Our Ref: STH10/00063/08
Contact: Andrea Boes 4221 2771
Your Ref: MP09_0088 File: 10/06041-2

Transport
Roads & Maritime
Services

**SHOALHAVEN CITY COUNCIL – MAJOR PROJECT 09_0088 – MIXED USE
SUBDIVISION, WEST CULBURRA – RESPONSE TO SUBMISSIONS**

The Overall Plan

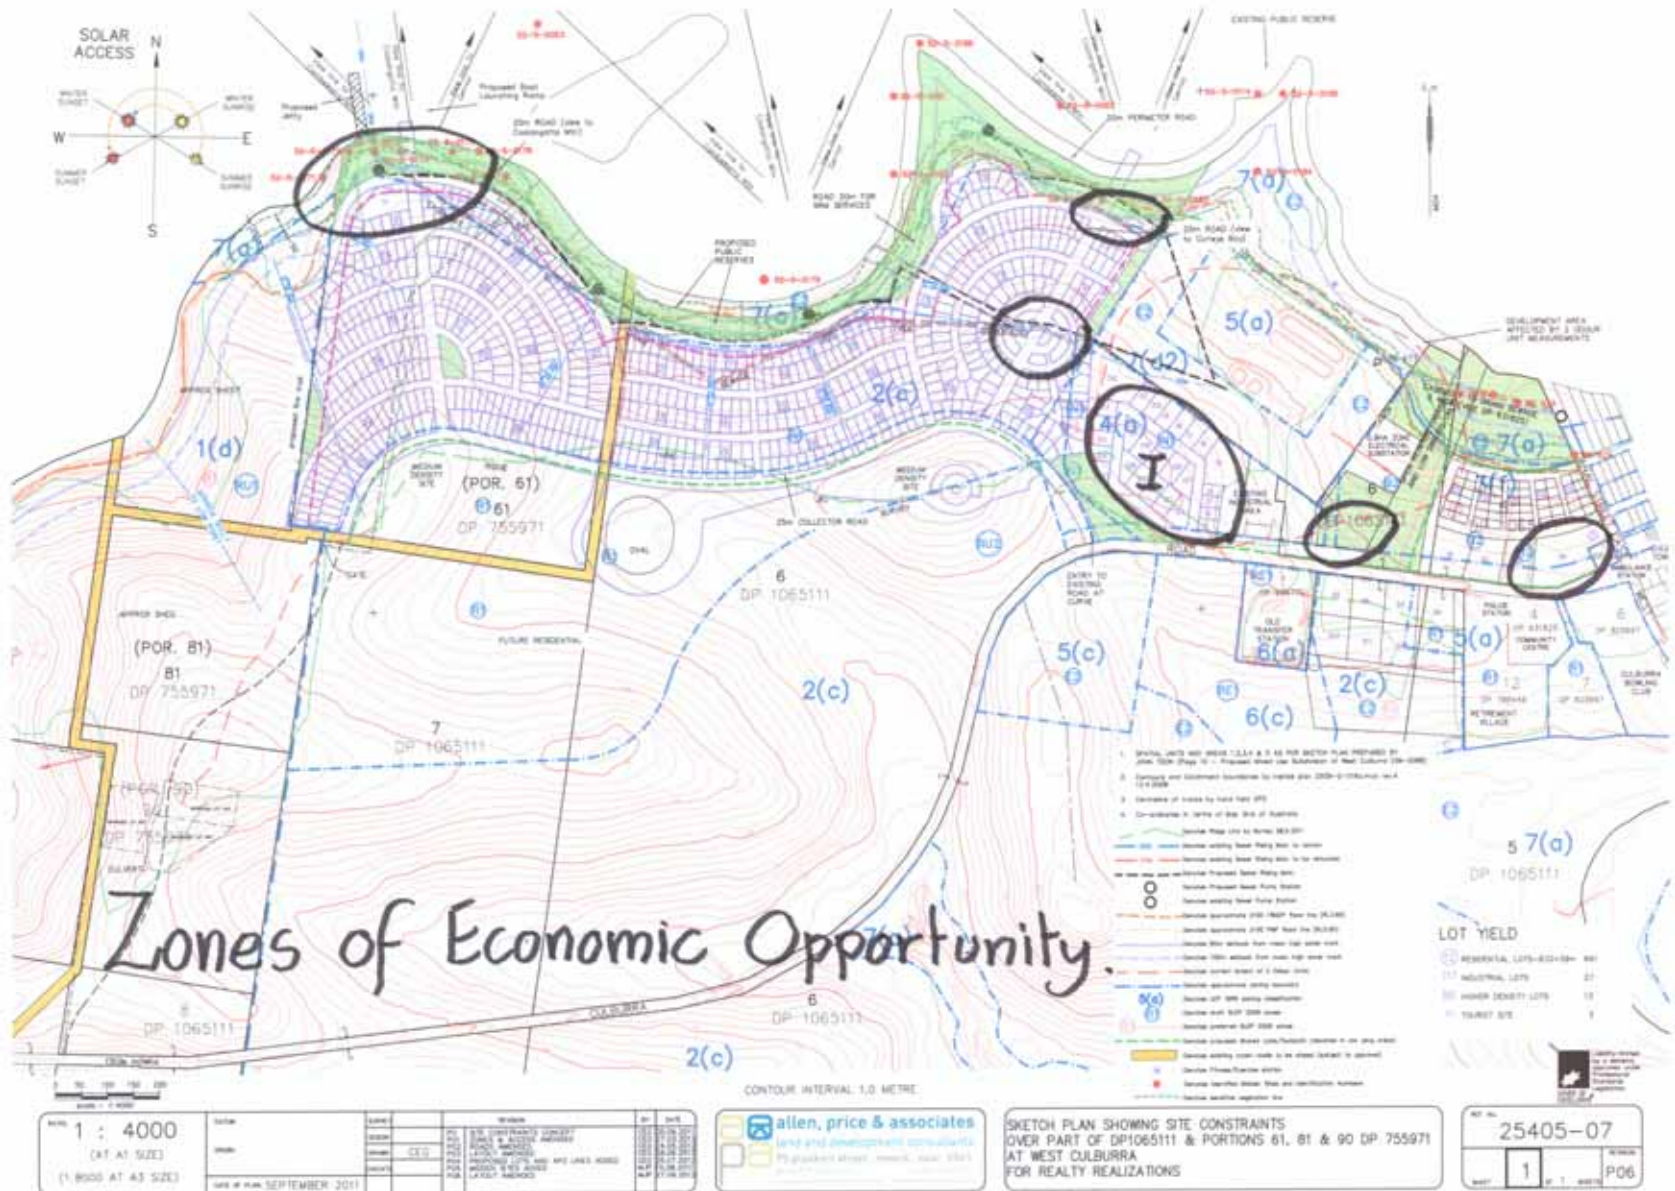
- RMS notes Section 9.3 of the report regarding the proposed roundabout on Culburra Road within the existing 100km/hr speed zone. RMS does not support roundabouts in speed zones over 80km/hr. As discussed in RMS' letter dated 7 June 2013, RMS considers that the existing 100km/hr speed zone at this location is appropriate and should be maintained. RMS maintains its concerns regarding the safety of a roundabout at this location. The developer should identify an appropriate intersection treatment to allow traffic to safely access the development within the existing speed zone (e.g., channelization).
